CASE : Application by Highways England for an Order Granting Planning Consent for the proposed Junction 10a M20 Motorway

Further representations following on from my initial response dated 12th January 2017 to The Examining Authority's first written questions

RIGHTS OF WAY AND ACCESS PLANS
REGULATION 5(2)(k) & 5(2)(o)
SHEET 3 OF 4

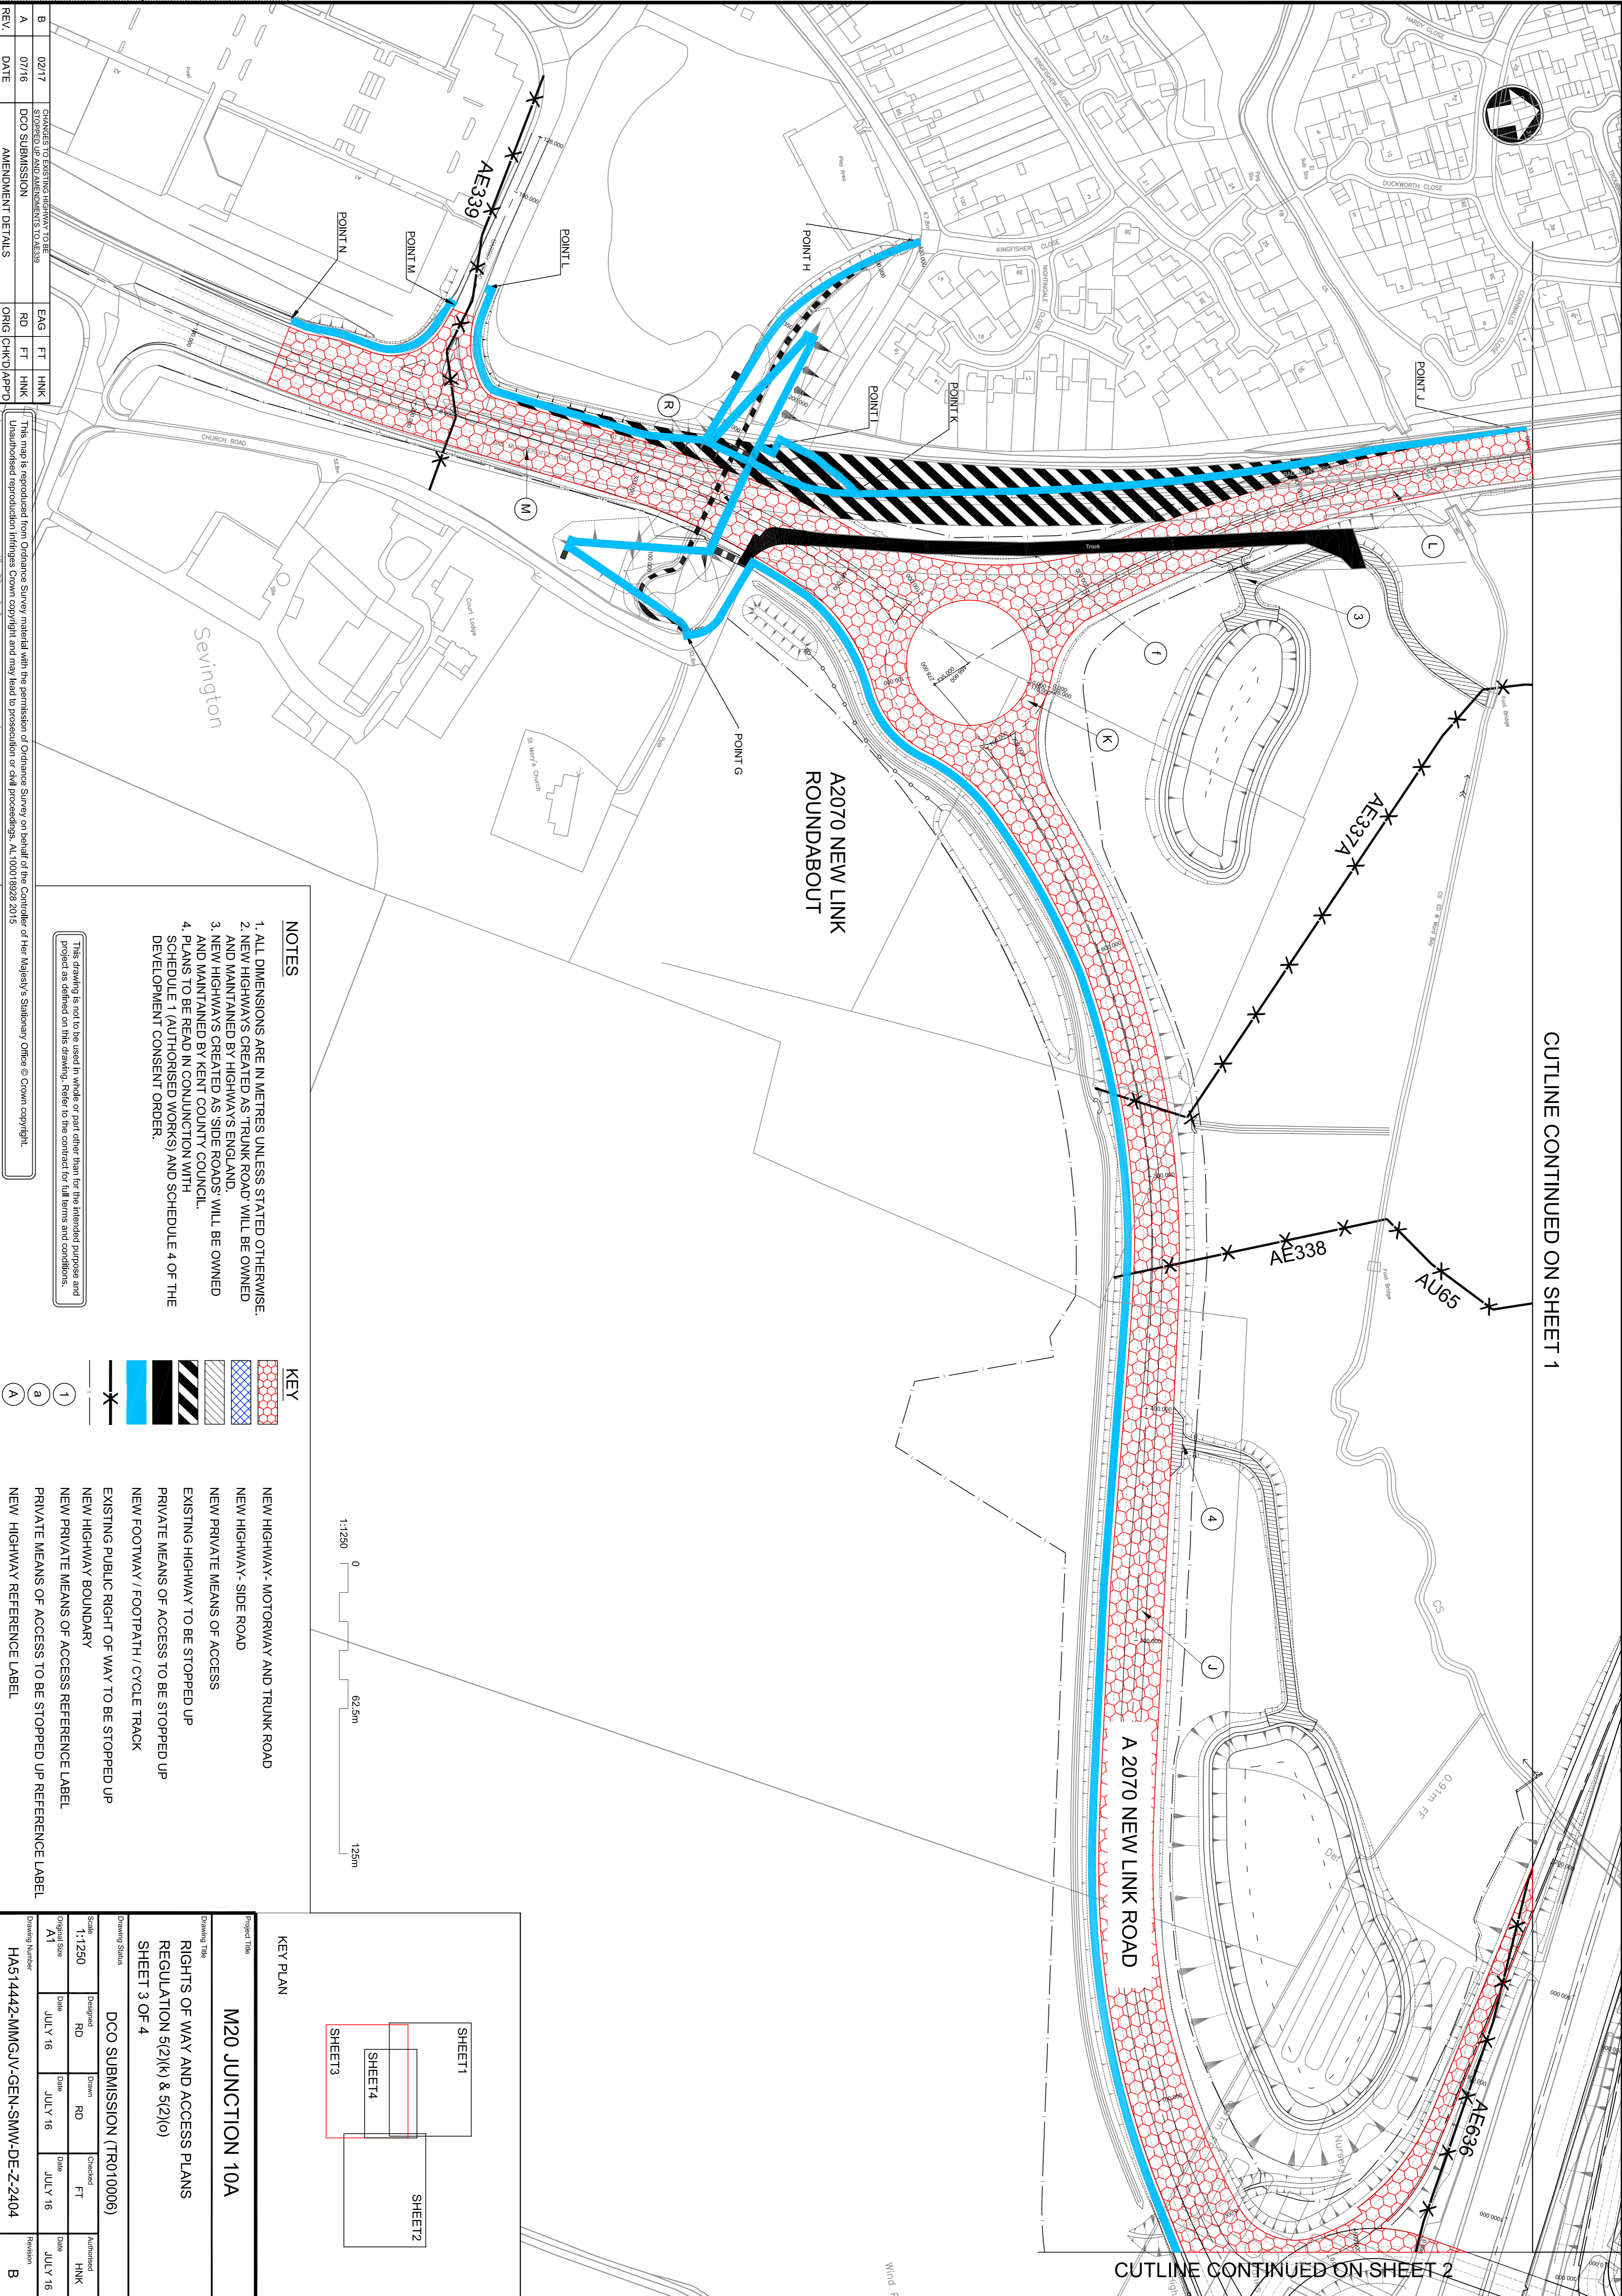
The grounds of objection 1 are that without provision for a fourth arm off the Stour Park Roundabout the scheme fails to make adequate advance provision for all potential access requirements necessary to maximise the use of the adjoining area and avoid a significant block of land being virtually landlocked.

I hasten to add that these objections can easily be resolved by the inclusion of a short stub of a fourth arm off the northern side of the roundabout.
